# CITY OF ALBUQUERQUE

**Re: Sawmill Market  
Erosion and Sediment Control Plan  
Engineer's Stamp Date 10-22-18 (J13D017A)**

Based upon the information provided in your submittal received 10-23-18, the above referenced plan is approved to be included in the SWPPP and for eNOI review for grading and Building Permit and for Work Order with the following conditions:

A1 EROSION AND SEDIMENT CONTROL PLAN
1" = 20'-0"

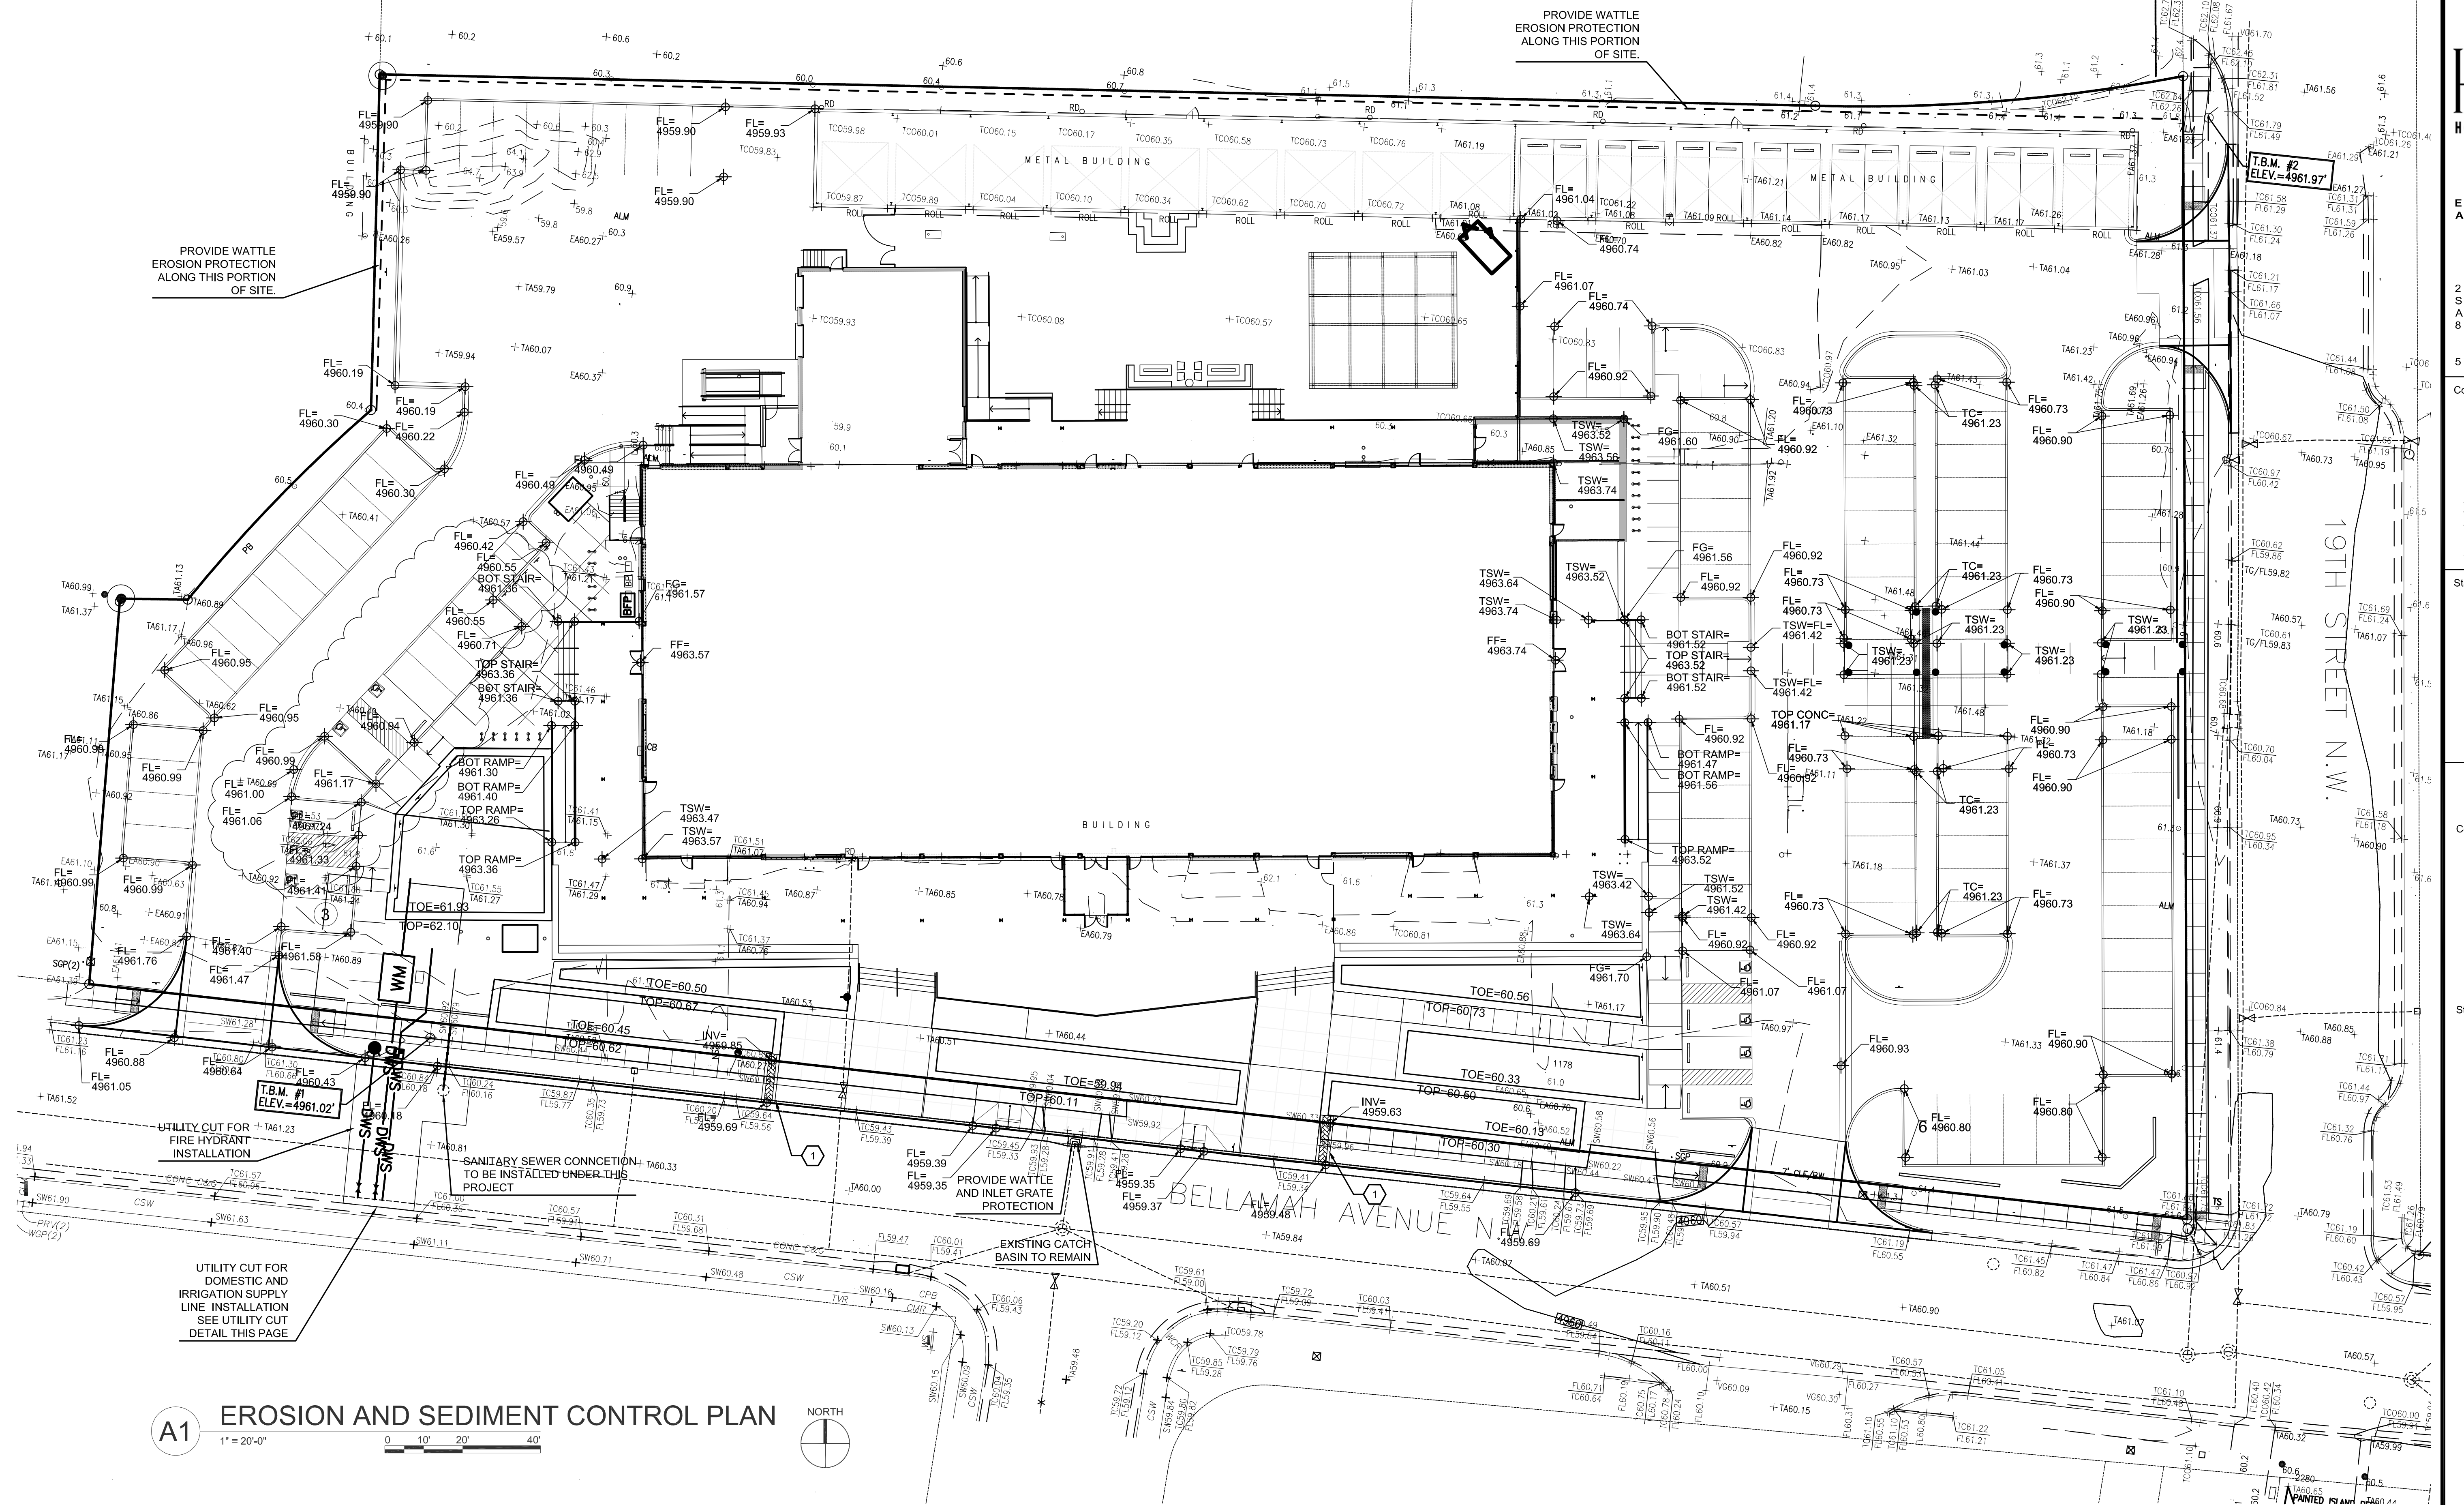
1. The site is to have Vehicle Tacking Control (track-out pad). If using a track-out pad: it is to be a minimum of 30 feet long, wide enough to not allow bypass, have fabric under the aggregate and the aggregate is to be a minimum of 3 inches in size.
2. A sediment BMP is required in the southwest edge of the site where the proposed grade is higher than the adjacent grade and, if necessary, along the southern edge where the same condition exists.
